# SEA LINK

EN020026

## Comments on submissions received by Deadline 1 and 1A

Suffolk County Council

Plate 2.1 Section of Benhall Bridge

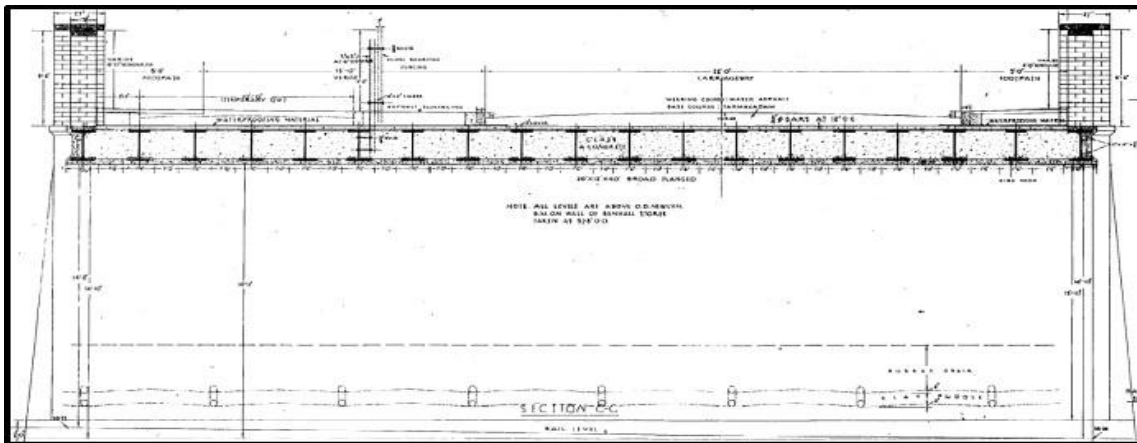
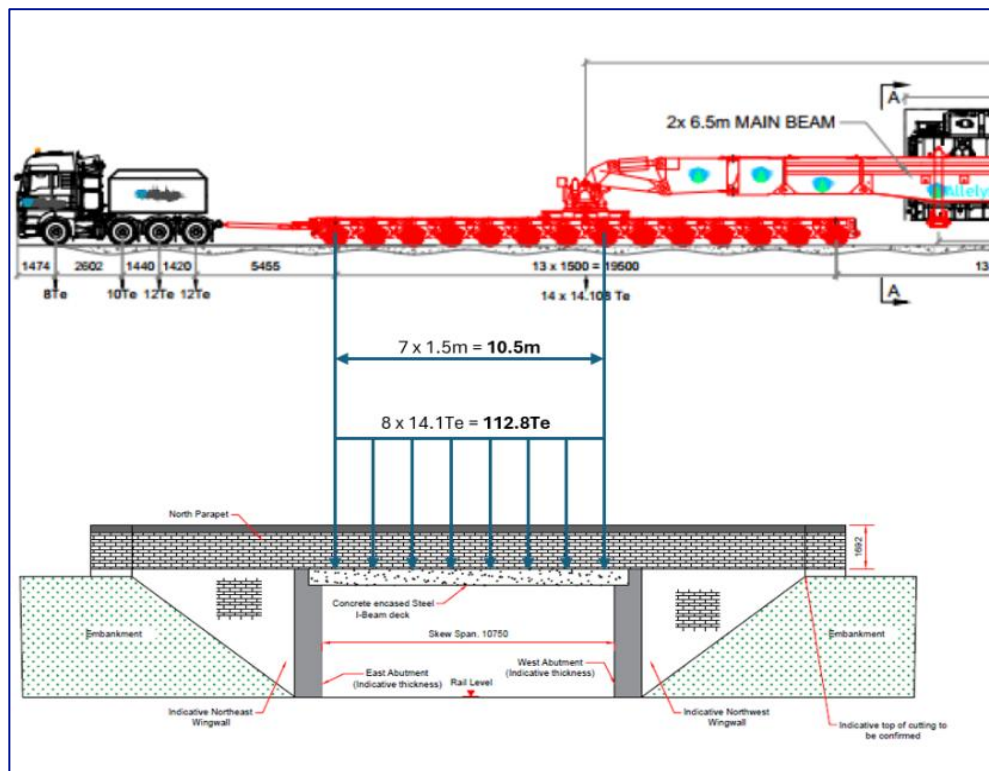
Ref. No	Topic	Summary of Submission	SCC Response	Document Ref(s)
<b>Table A5 - 2.9 Traffic and Transport</b>				
A5.1	<b>Benhall Railway Bridge RR 86 - 87</b>	The Applicant gives details in relation to the options for implementing AIL access over the Benhall Railway Bridge included in the Application.	<p>The Applicant's response does not address SCC's concerns around the use of the bridge for AIL movements. The impacts of the 'mini bridge' option have not been fully assessed, such as the greater levels of traffic at nearby A12 junctions during closures of the bridge. It should be noted that SCC understands from its engagement with the Applicant that each AIL movement across the bridge will require a three-day closure of the bridge for the installation, AIL movement and removal of the mini bridge. In this scenario, closure of the bridge cannot be fully accommodated within a weekend and would interact with weekday levels of traffic which includes those generated from Sizewell C, EA1N and EA2 using the A12.</p> <p>Whilst SCC recognises that a three-day closure would cause temporary effects, SCC understands that repeated closures would be required for each AIL movement. SCC would appreciate clarity on the number of closures of the Benhall Rail Bridge required for the Applicant to retain this option so that the worst-case scenario of duration of effect can be established</p> <p>Other details including what Temporary Traffic Management measures will be implemented to mitigate impacts have also not been provided. Drawings showing indicative design and layout of the option have not been</p>

Ref. No	Topic	Summary of Submission	SCC Response	Document Ref(s)
			<p>provided either, meaning the feasibility of the option is unclear. The lack of crucial details and assessments means that neither SCC nor the ExA can have full knowledge of the impacts this scenario could have.</p> <p>SCC is unable to evaluate the feasibility of potential mitigation measures and questions the Applicant's confidence that it will be able to minimise impacts to a sufficient extent without any detail of these potential measures being provided.</p> <p>SCC considers this lack of assessment to contradict Advice Note 9 which states: <i>"4.9 If, in the course of preparing an ES, it becomes clear that it will not be possible to specify all the details of the Proposed Development, the ES must explain why and how this has been addressed. The ES will need to establish the relevant parameters for the purposes of the assessment. Where this approach is adopted the assessments in the ES should be undertaken on the basis of the relevant design parameters applicable to the characteristics of the Proposed Development included within the DCO. The assessment should establish those parameters likely to result in the maximum adverse effect (the worst-case scenario) and be undertaken accordingly to determine significance."</i></p>
